Our ref: HA/2021/123361/01-L01
Your ref: AL/87/21/PL
Date: 21 July 2021

ERECTION OF A WAREHOUSE (USE CLASS B8) WITH ANCILLARY OFFICE, ASSOCIATED VEHICLE PARKING, VAN STORAGE, PLANT, ANCILLARY STRUCTURES, LIGHTING LANDSCAPING AND INFRASTRUCTURE WORKS INCLUDING EARTHWORKS TO FACILITATE FLOOD COMPENSATION AREA. THIS SITE MAY AFFECT LISTED BUILDINGS, MAY AFFECT THE CHARACTER & APPEARANCE OF THE SHRIPNEY CONSERVATION AREA, IS A DEPARTURE FROM THE DEVELOPMENT PLAN, AFFECTS A RIGHT OF WAY & IS IN CIL ZONE SP3 (ZERO RATED) AS OTHER DEVELOPMENT. OLDLANDS FARM NEWLANDS ROAD BOGNOR REGIS PO22 9FJ

Environment Agency Position

## Drawing 1 – Flood Compensation Area, Proposed Area

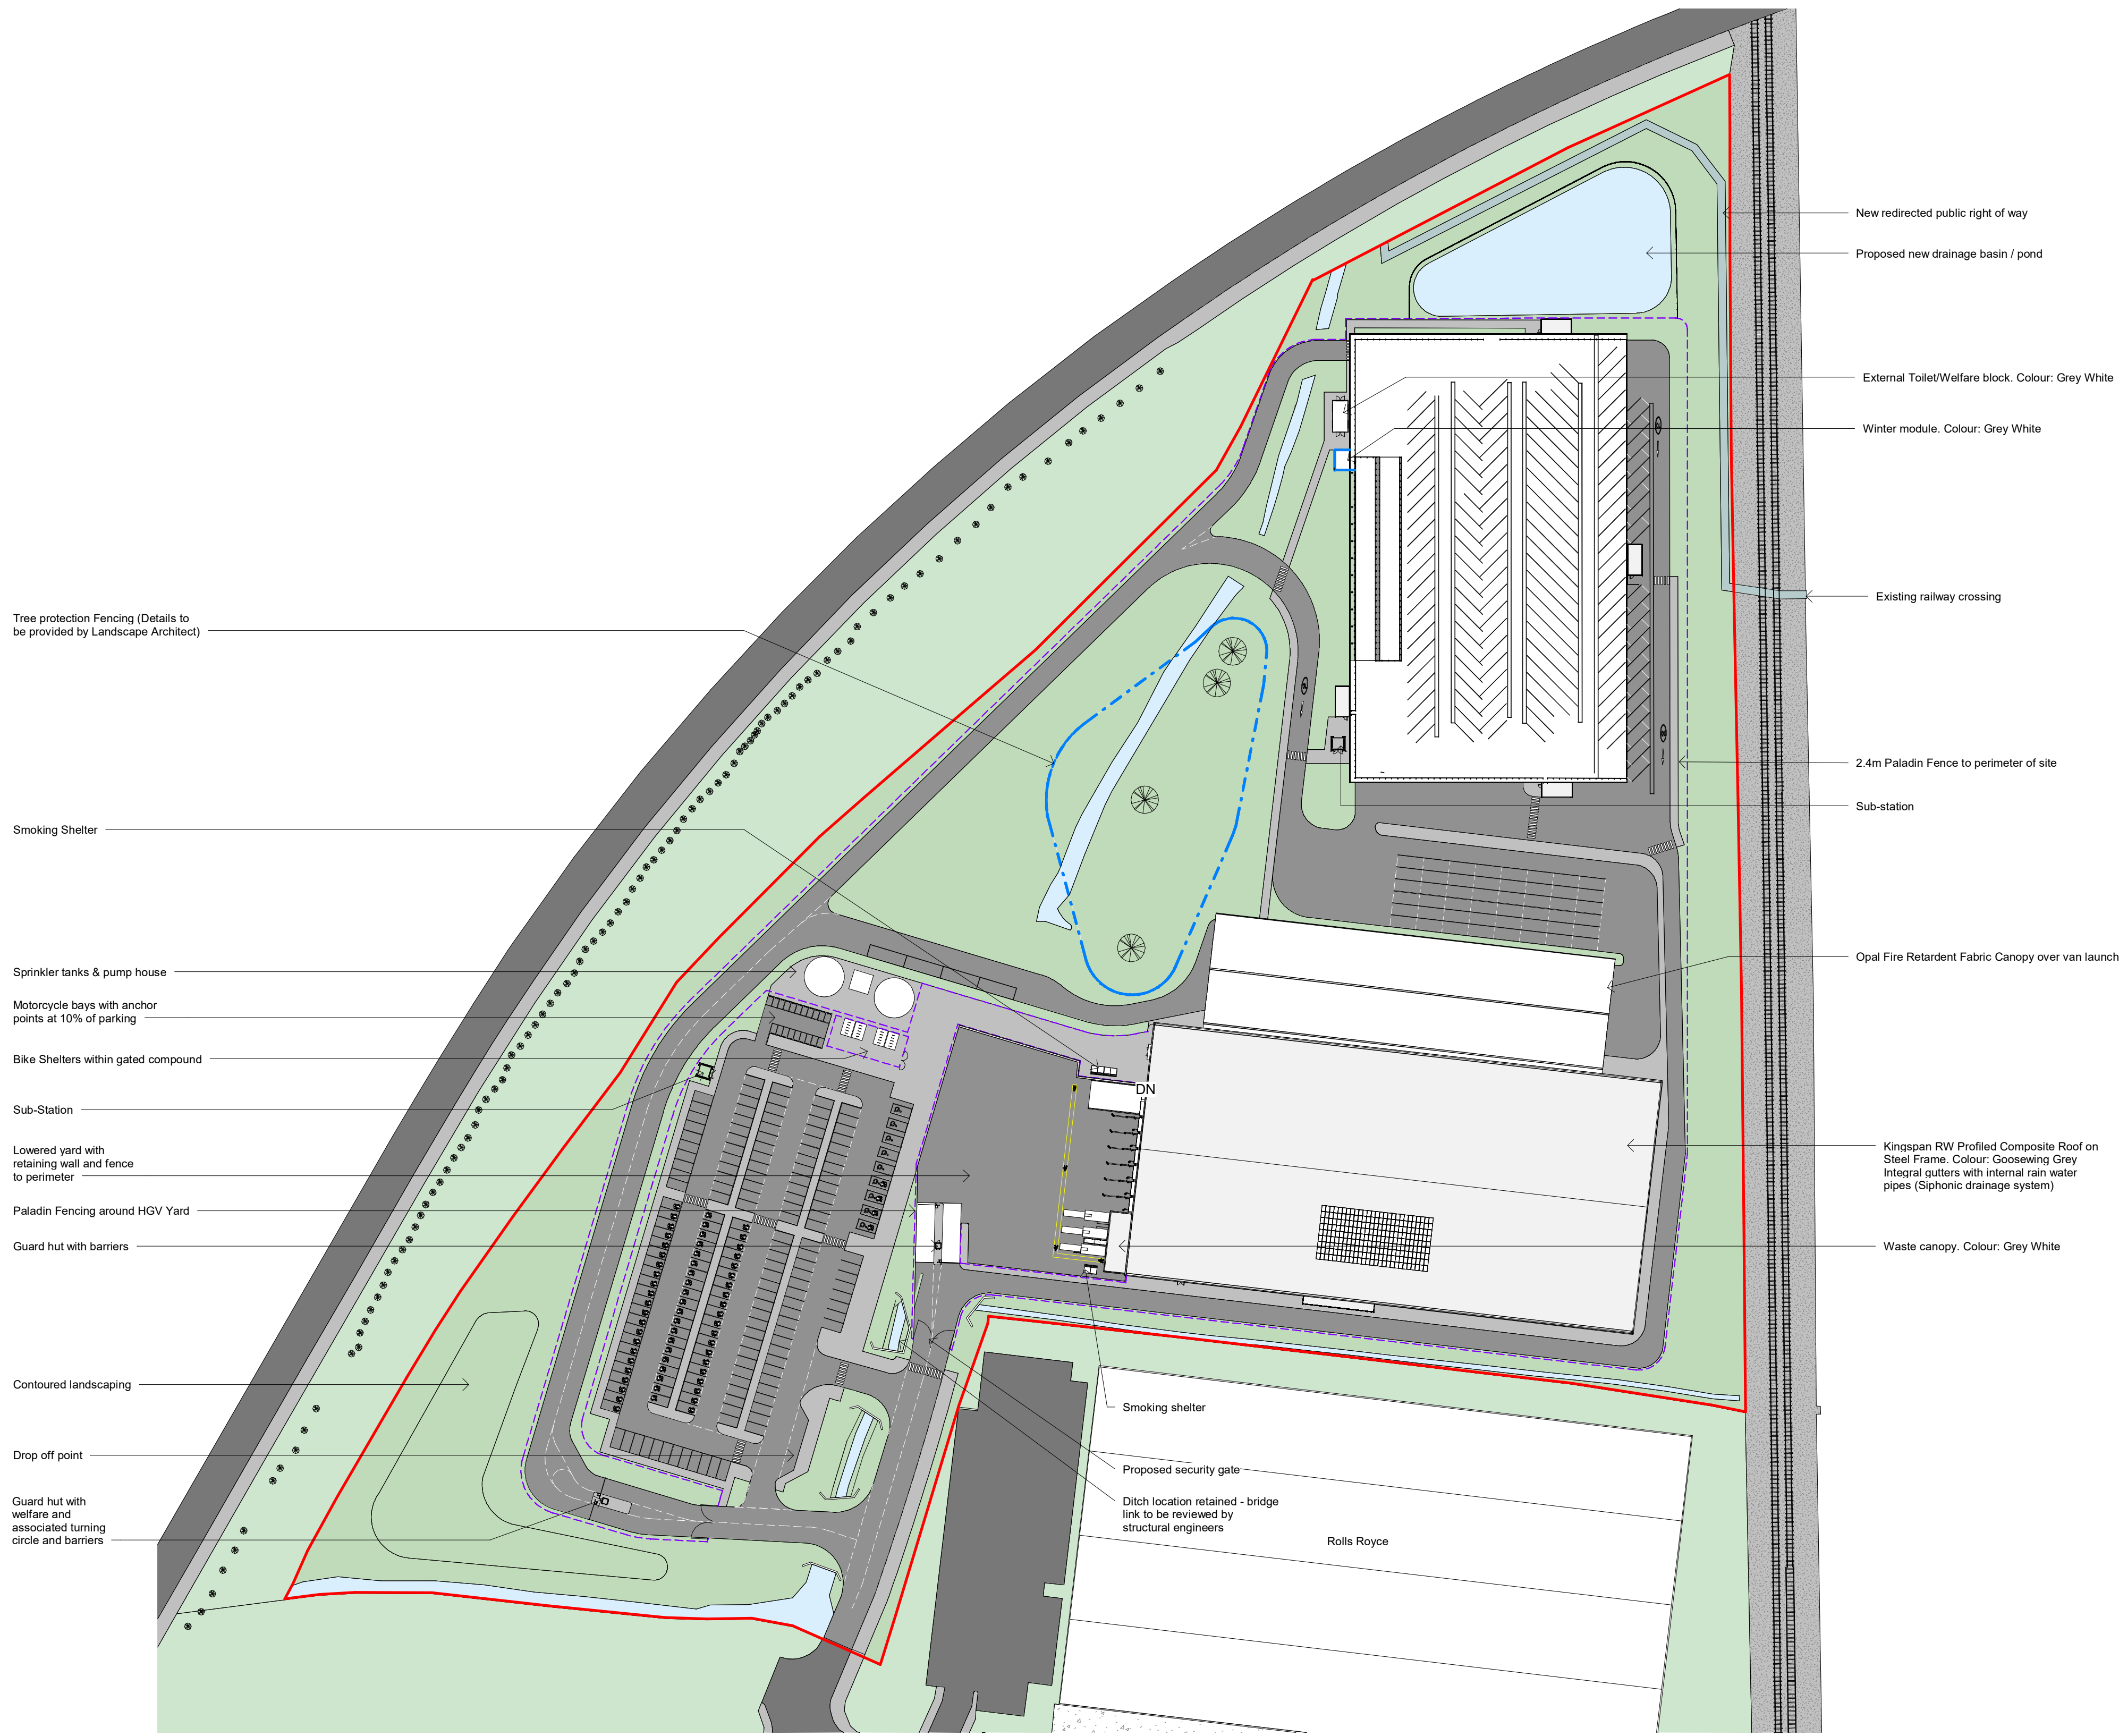
- Finished floor levels shall be set no lower than 3.65 metres above Ordnance Datum (AOD)
- Compensatory storage shall be provided North of the site as shown in the contour map (Drawing ref. 21023-ASA-XX-XX-DR-A-PL17-(S2-P1))
